# EL PASO COUNTY STORMWATER MANAGEMENT PLAN CHECKLIST

Revised 5/21/07

GRADING &  
EROSION  
PLAN

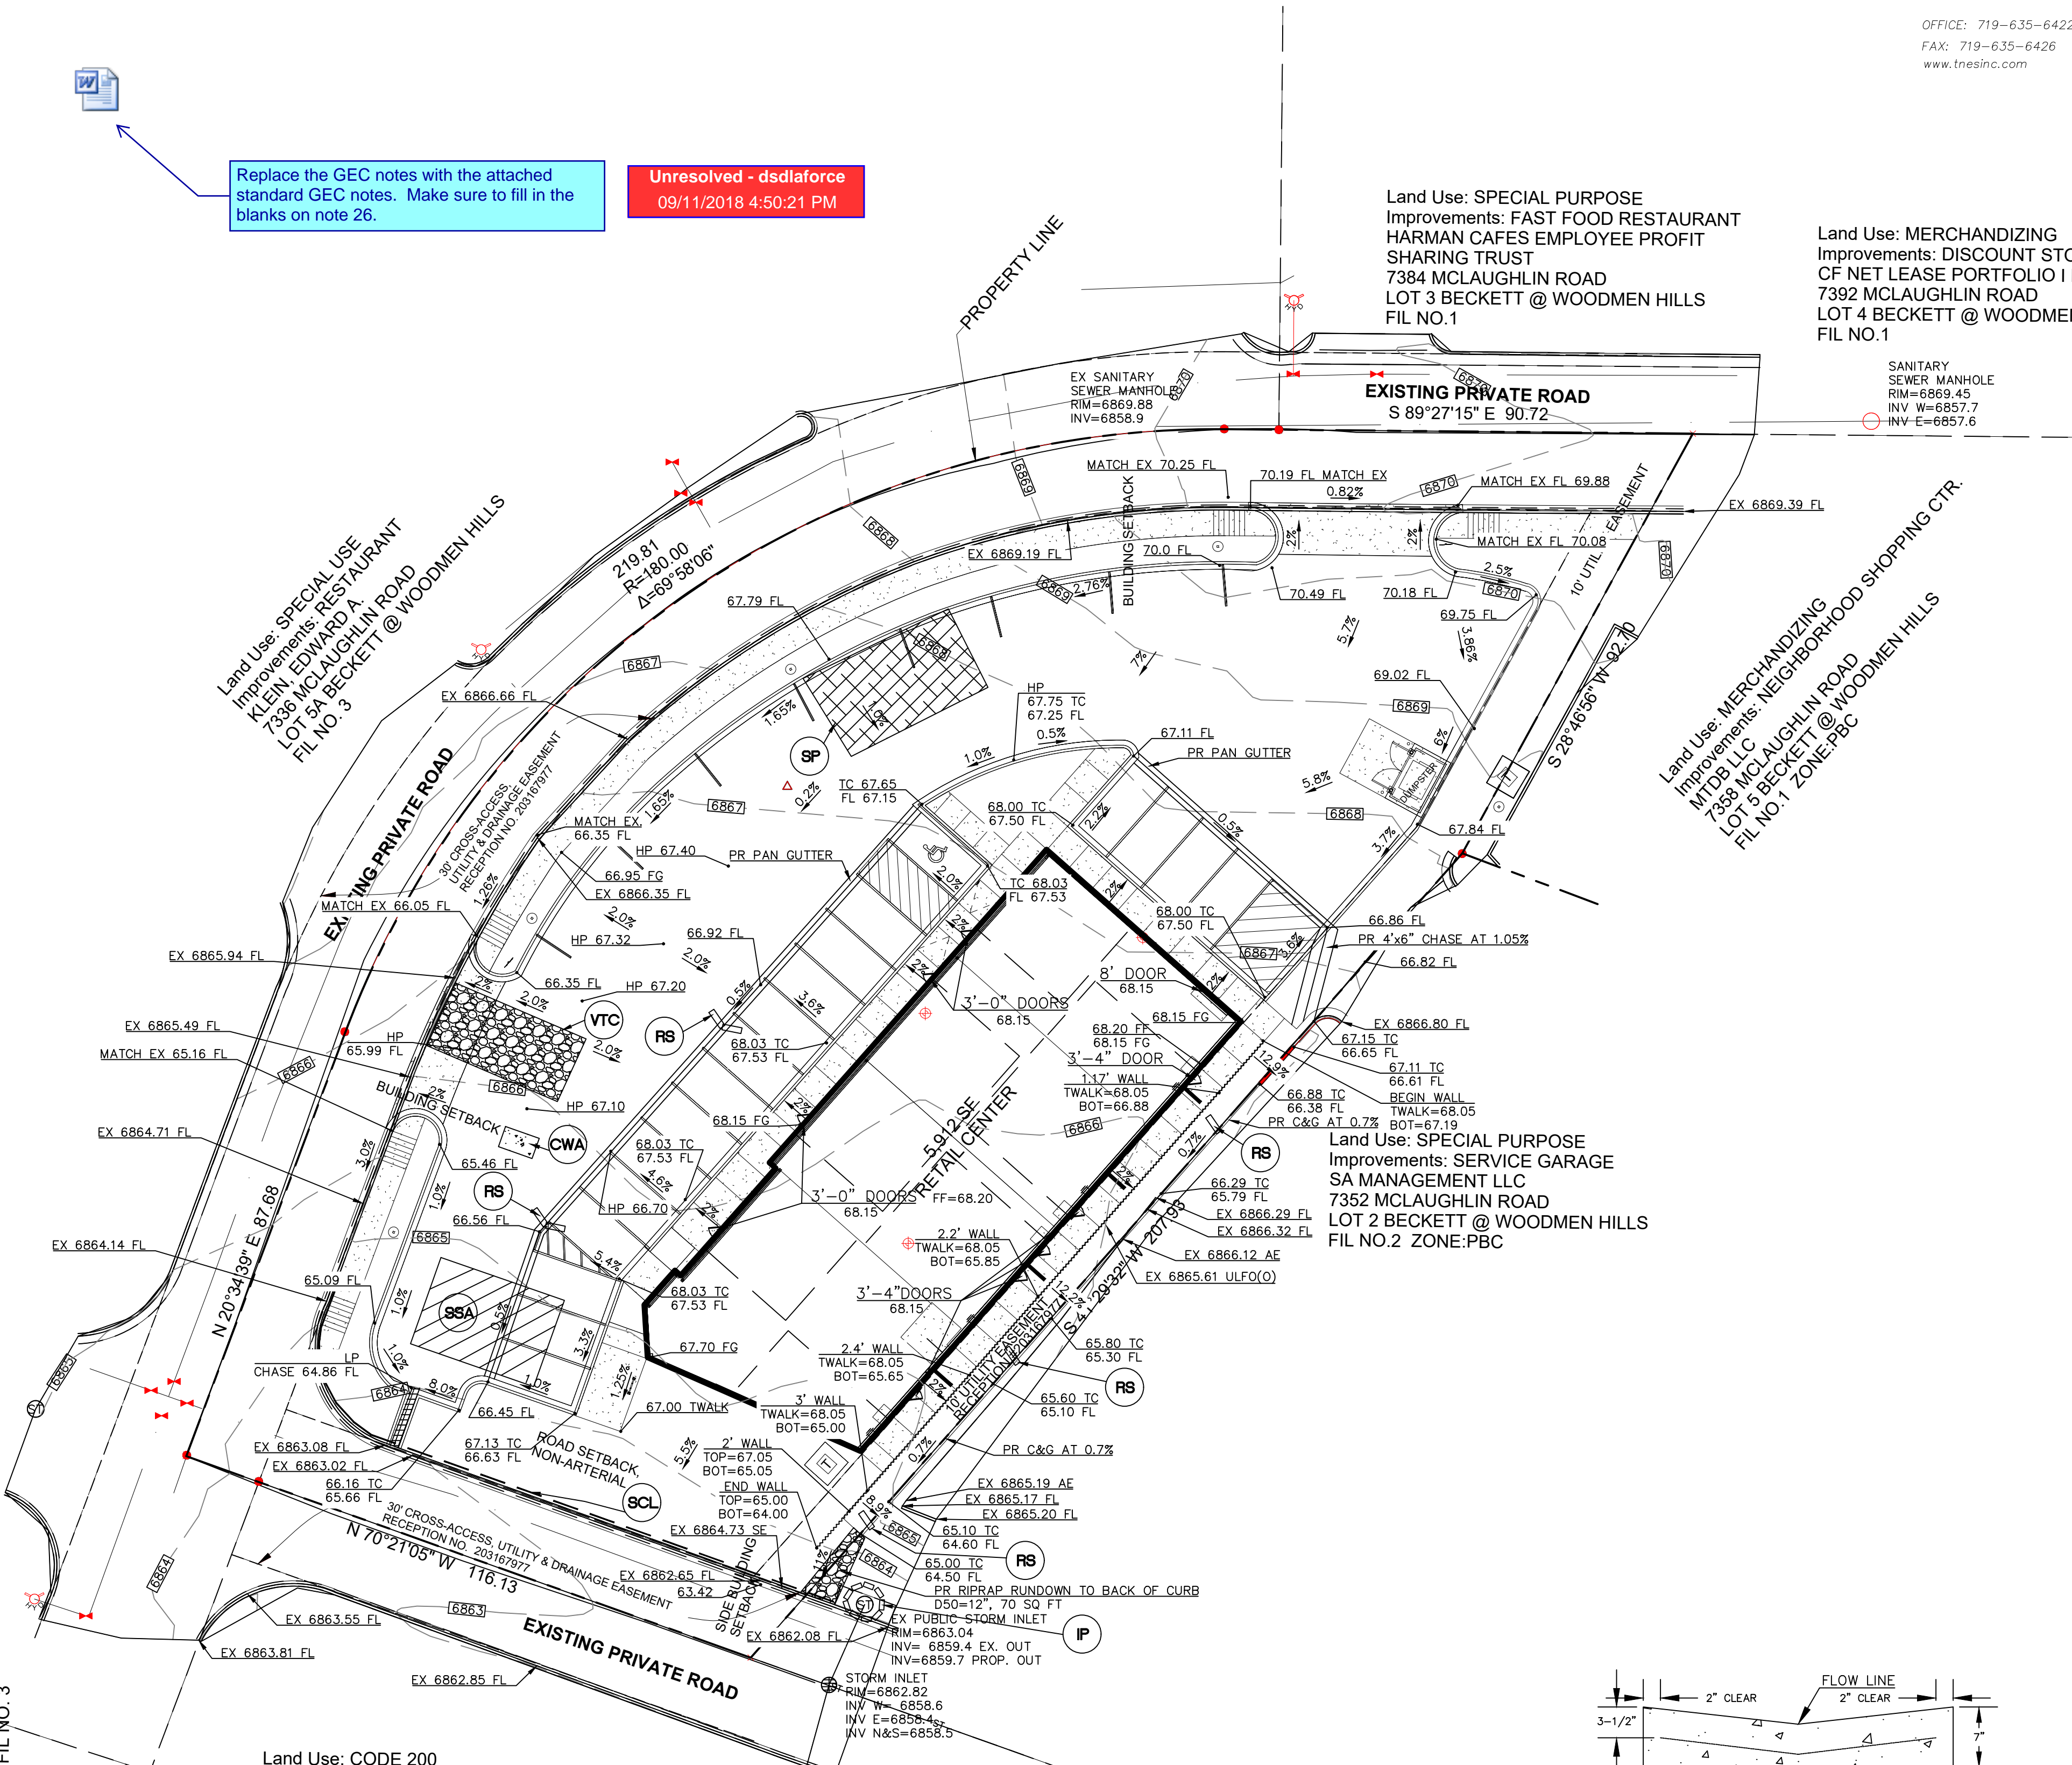
Was not included in the submittal.
